Please see LU/261/15/HH

From: Studio5 Architects [REDACTED]
Sent: 23 October 2015 10:15
To: David Easton
Subject: 15.903 10 Mariners Quay_amended drawing 15.903-TP01D

SCALE
AS SHOWN@A1
PROJECT NO.
15.903
DATE
Aug 2015
DRAWING NO.
TP01D

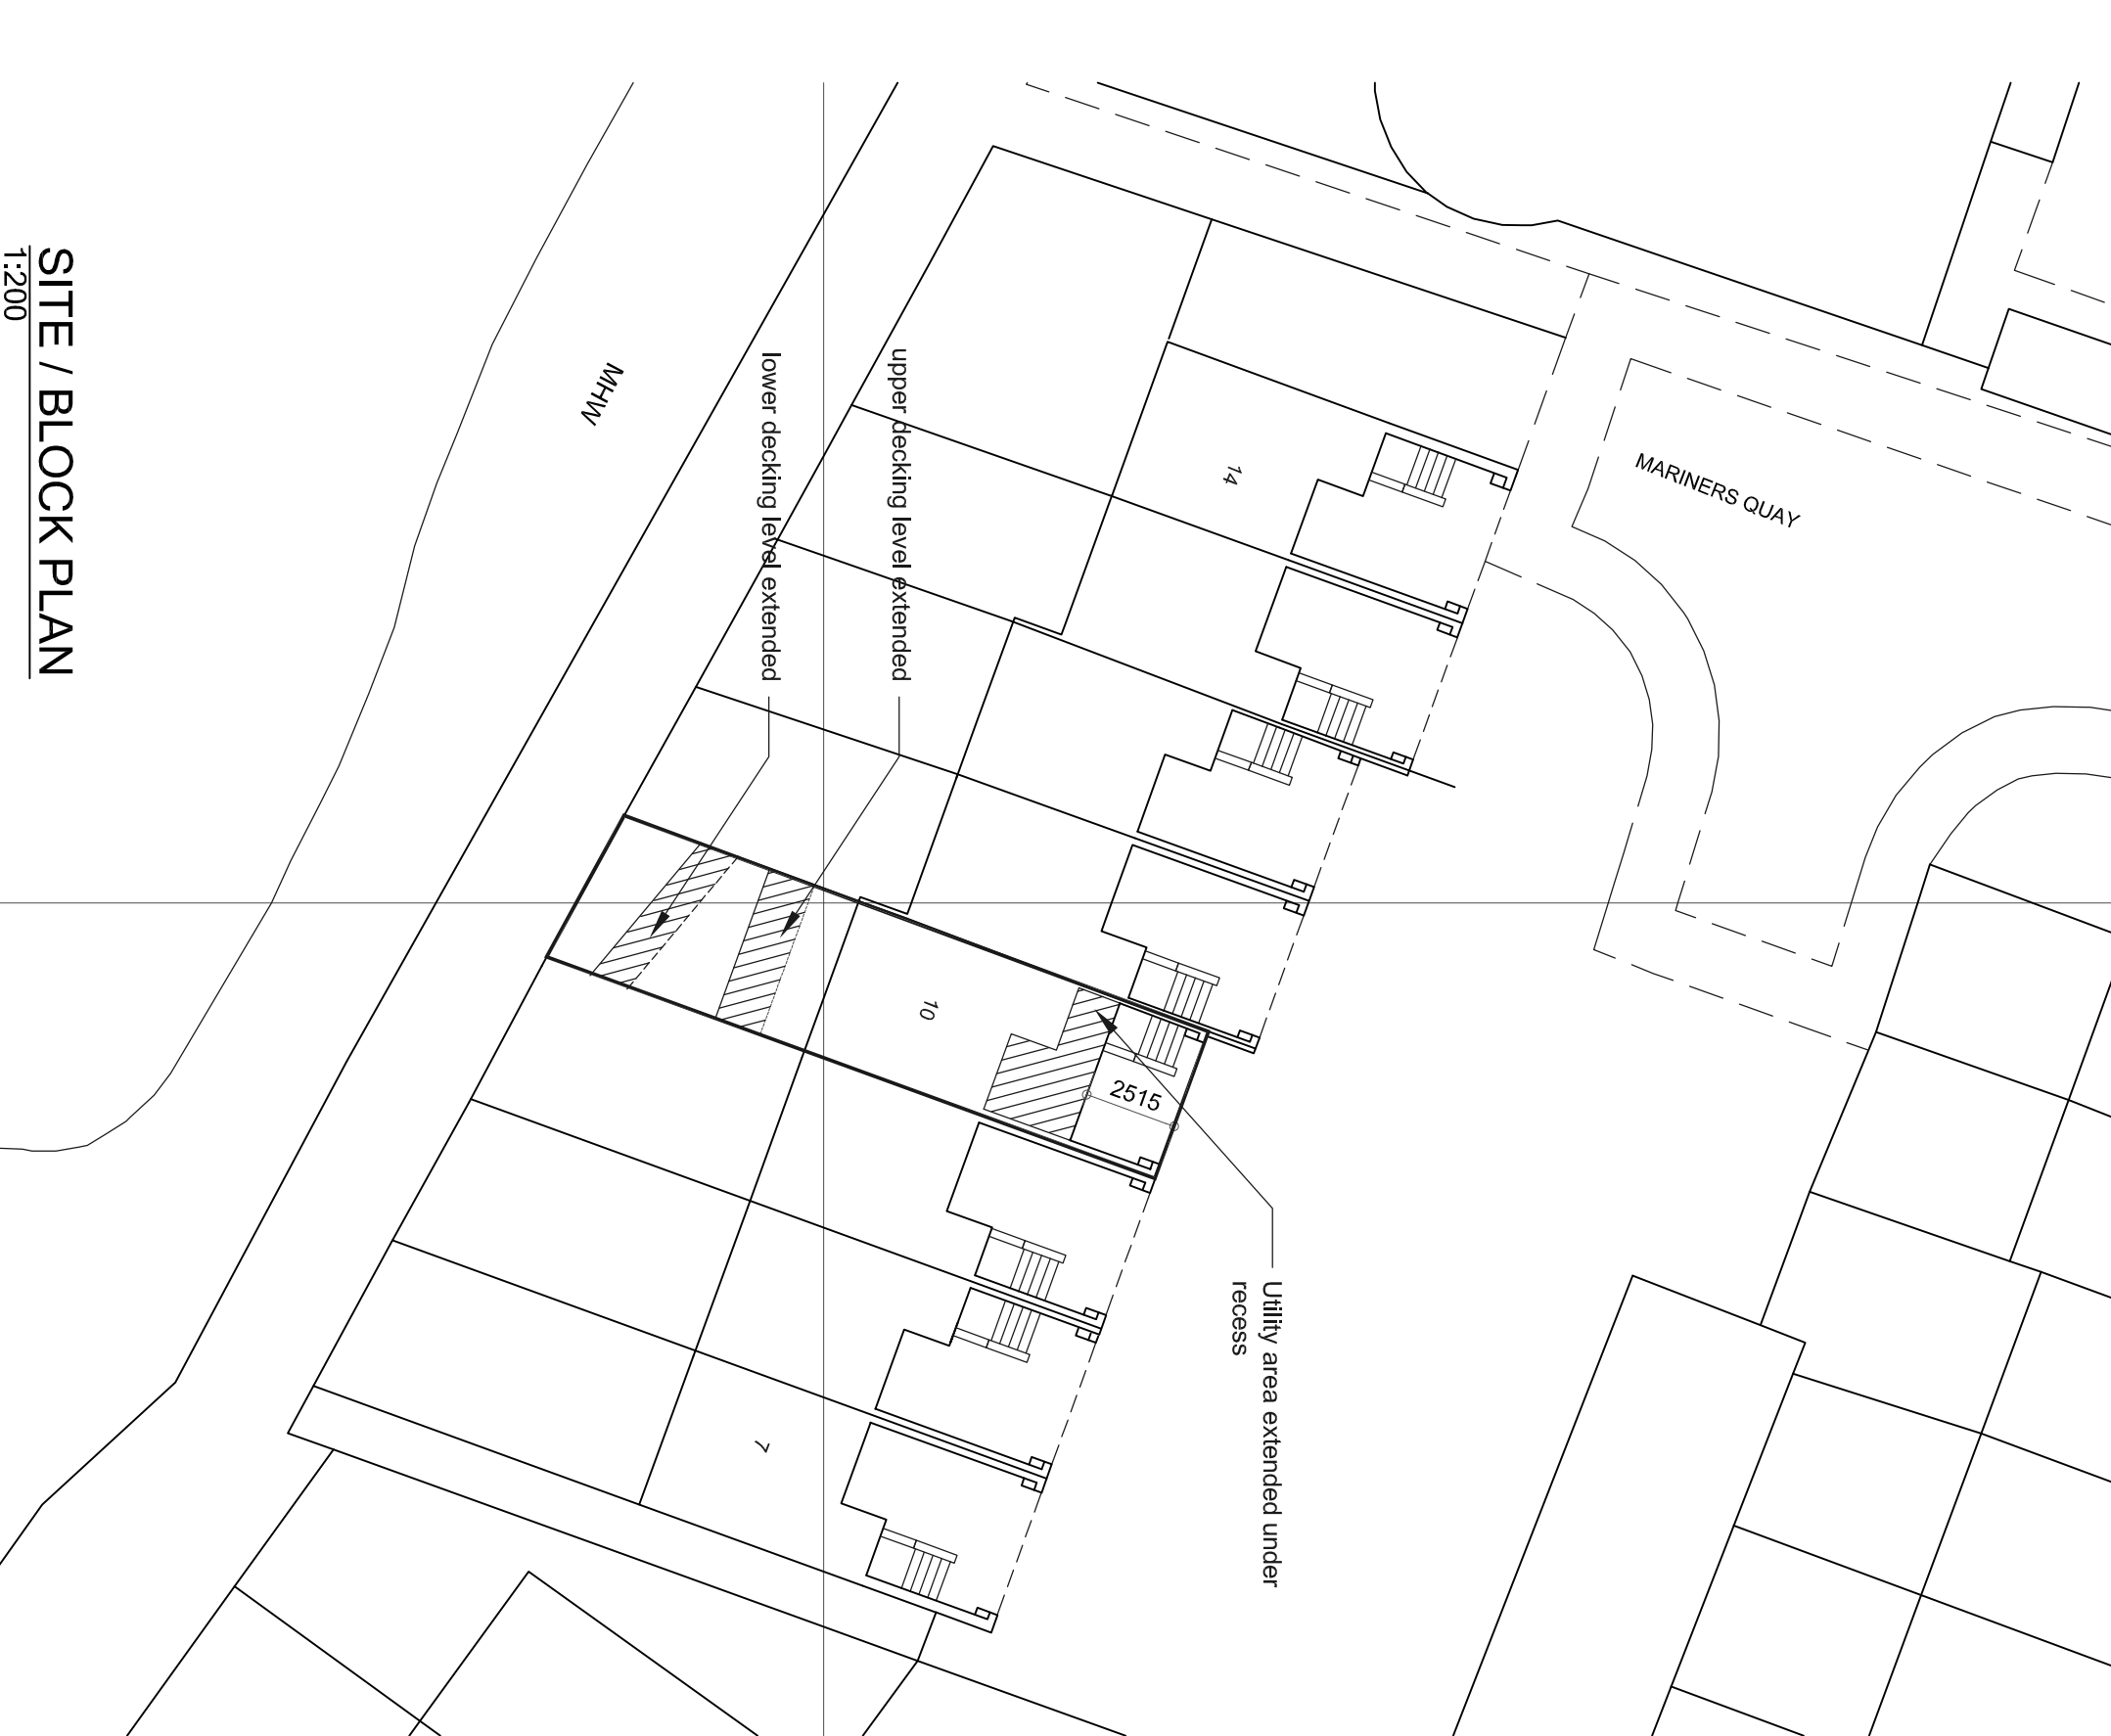
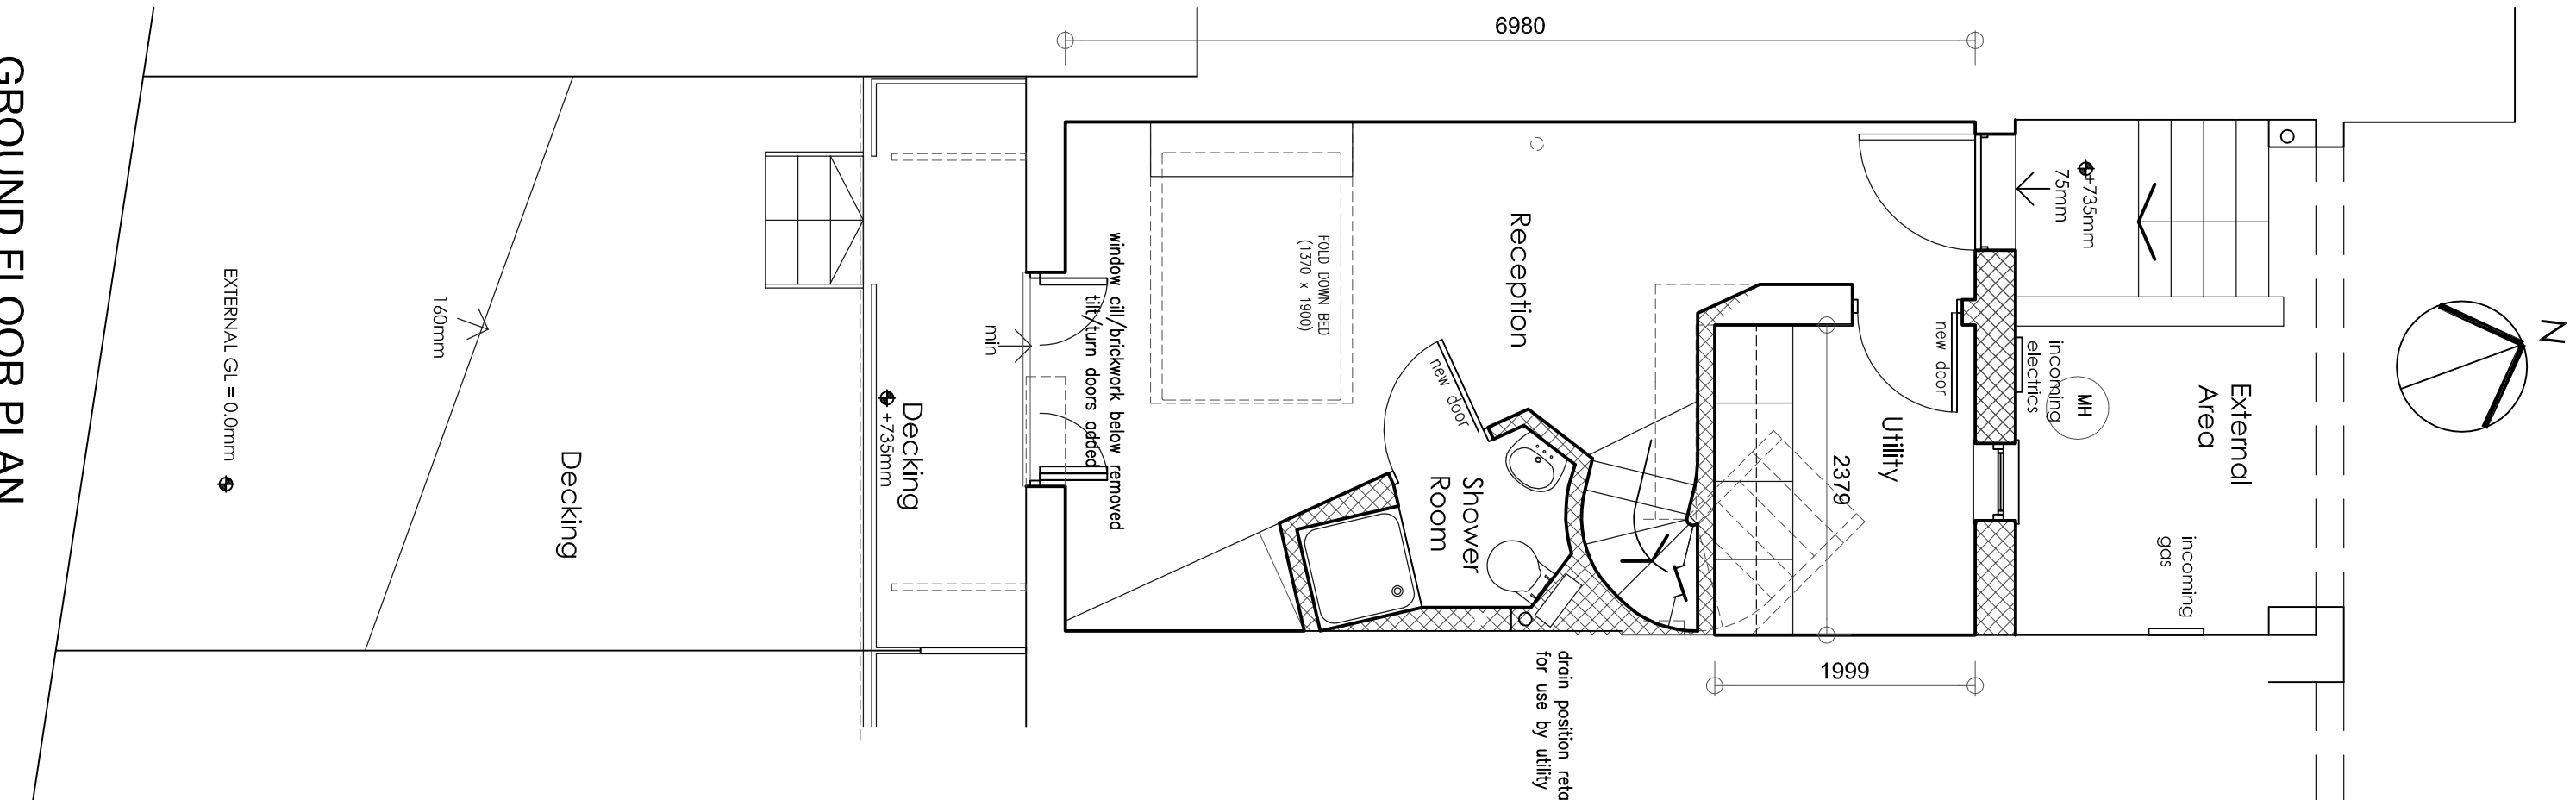
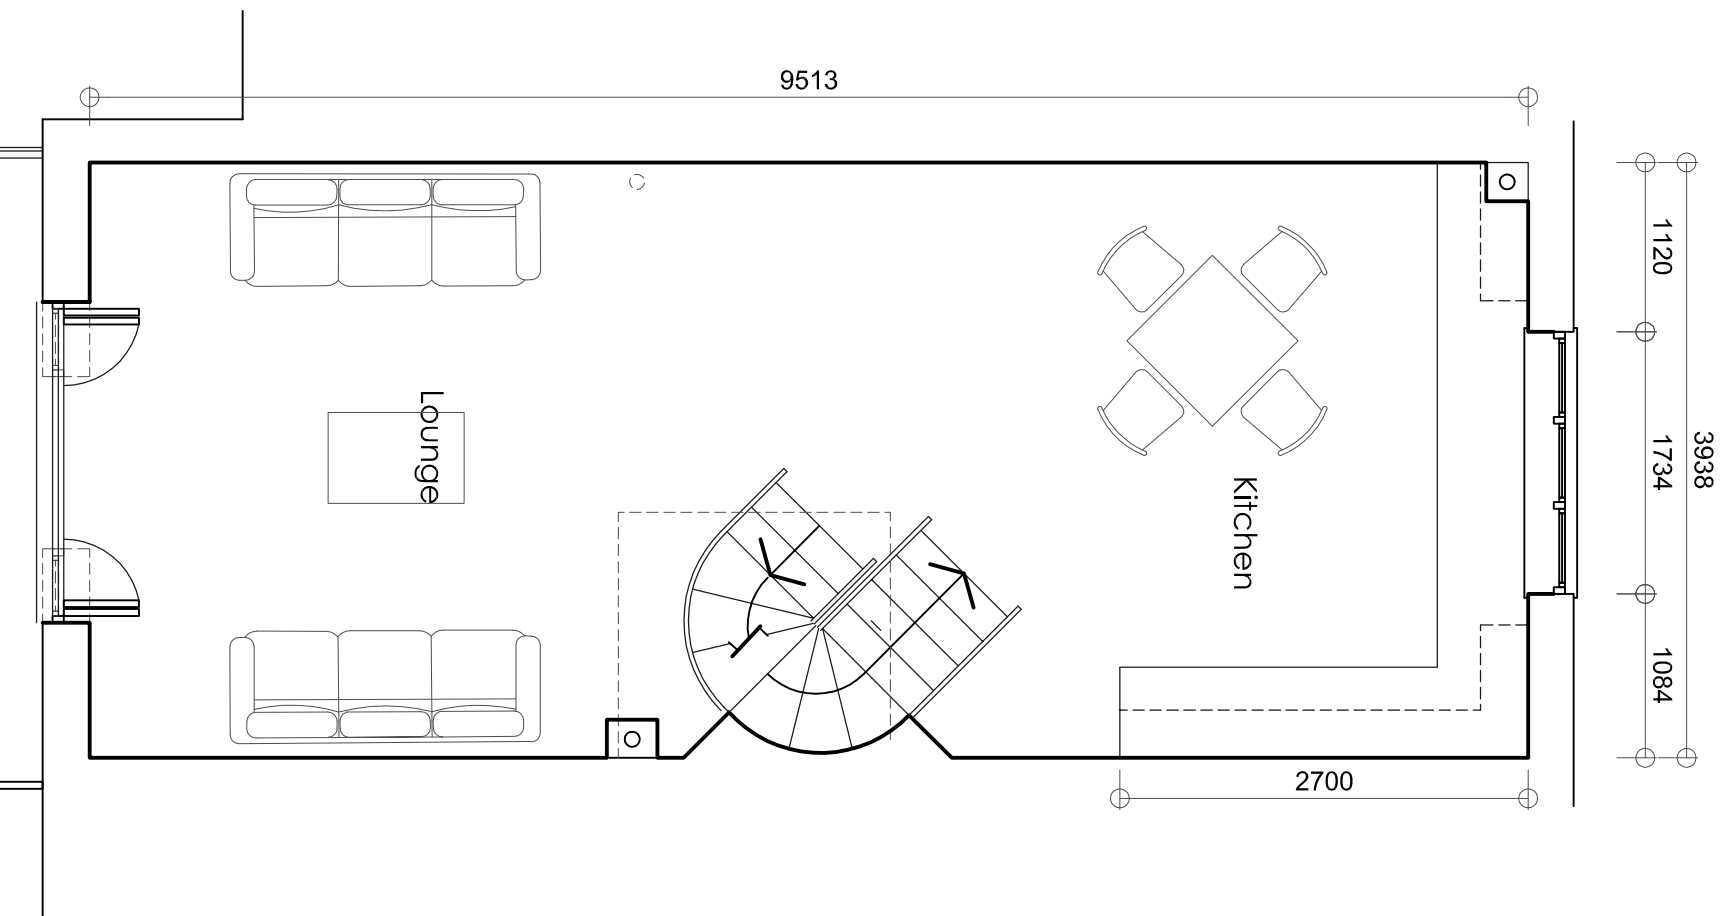
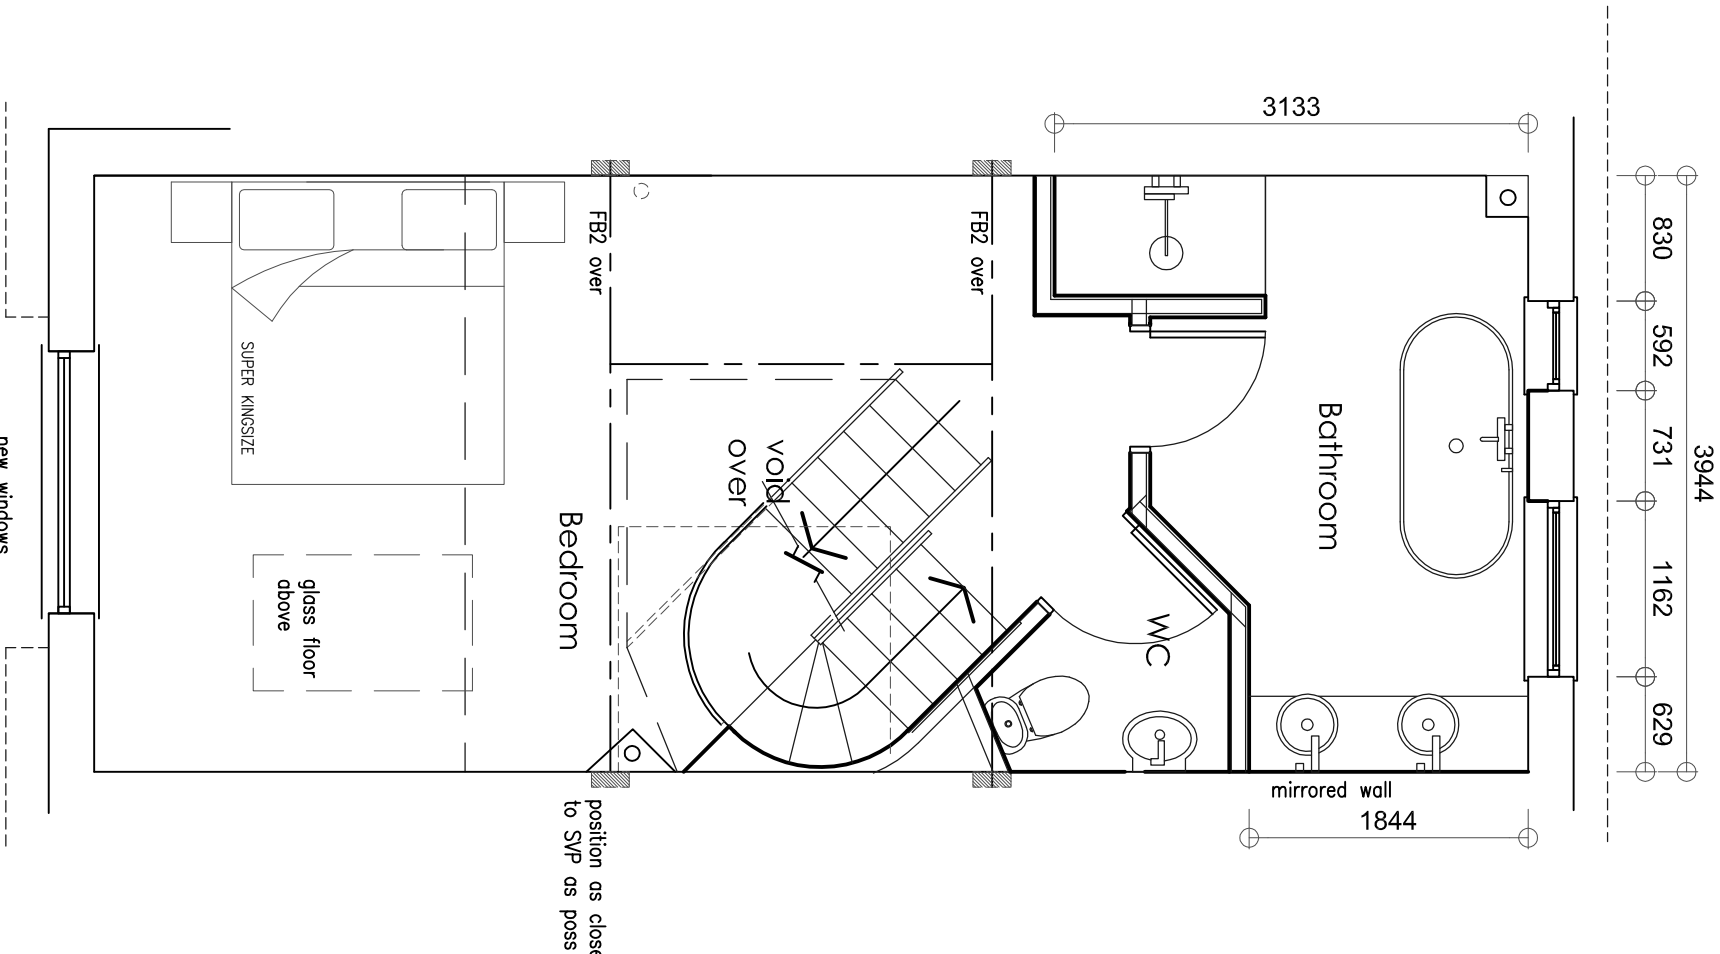
Further to our earlier phone conversation regarding the omission of the Lifting beam, please find attached amended drawing 15.903-TP01D.
